DEVELOPMENT FACILITATION TEAM

DRB Project Number: 2018-001579
2160 Louisiana-Winrock Center

SUBJECT: Sketch

Project Name: Winrock Town Center

SKETCH PLAT FOR
WINROCK TOWN CENTER
TRACT Z-1-A, TRACT H-1 &
TRACT K
HUNT-SPECTRUM
DEVELOPMENT SITE
TRACT B-1

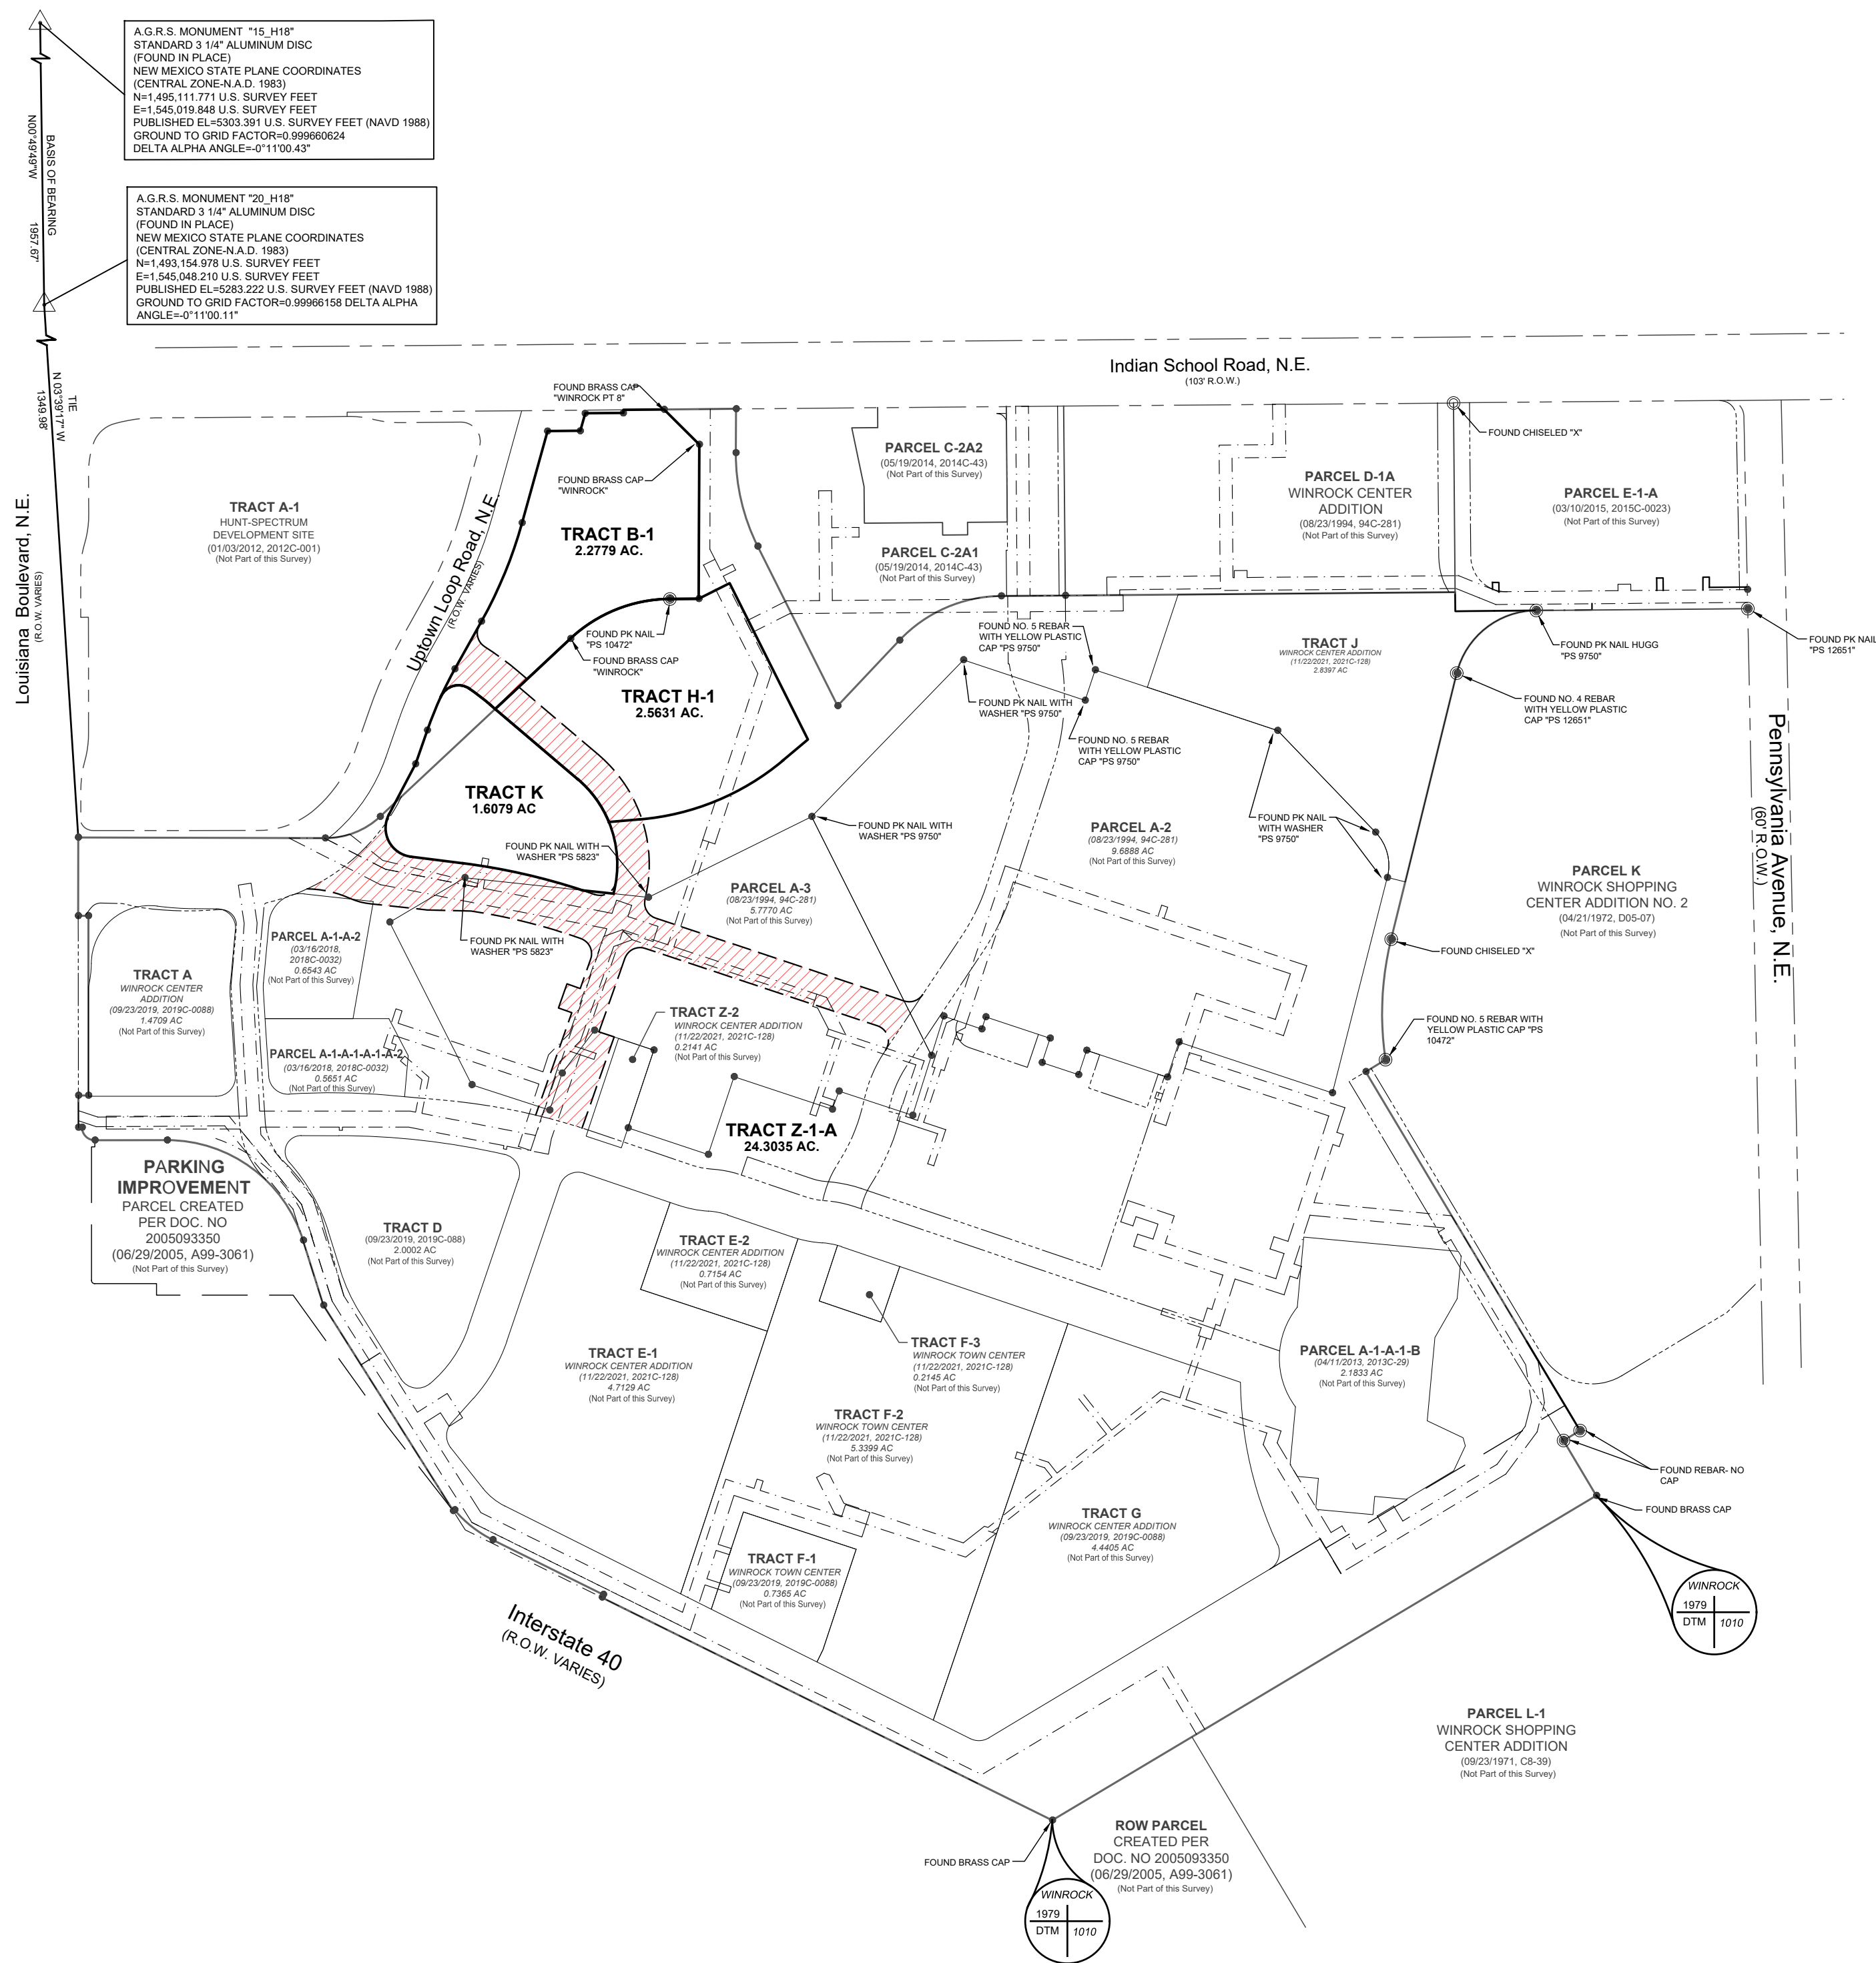
1. Louisiana is a Principal Arterial within a Center and requires 10' sidewalk with a 6' to 8' landscape buffer. All other adjacent roads are private and require 5' sidewalks. Please provide dimensions of all existing sidewalks and buffers to determine if widening is required.

- **Demonstrate compliance with section 7 of the DPM, Table 7.2.29, regarding Sidewalk width requirements and its landscape buffer.**
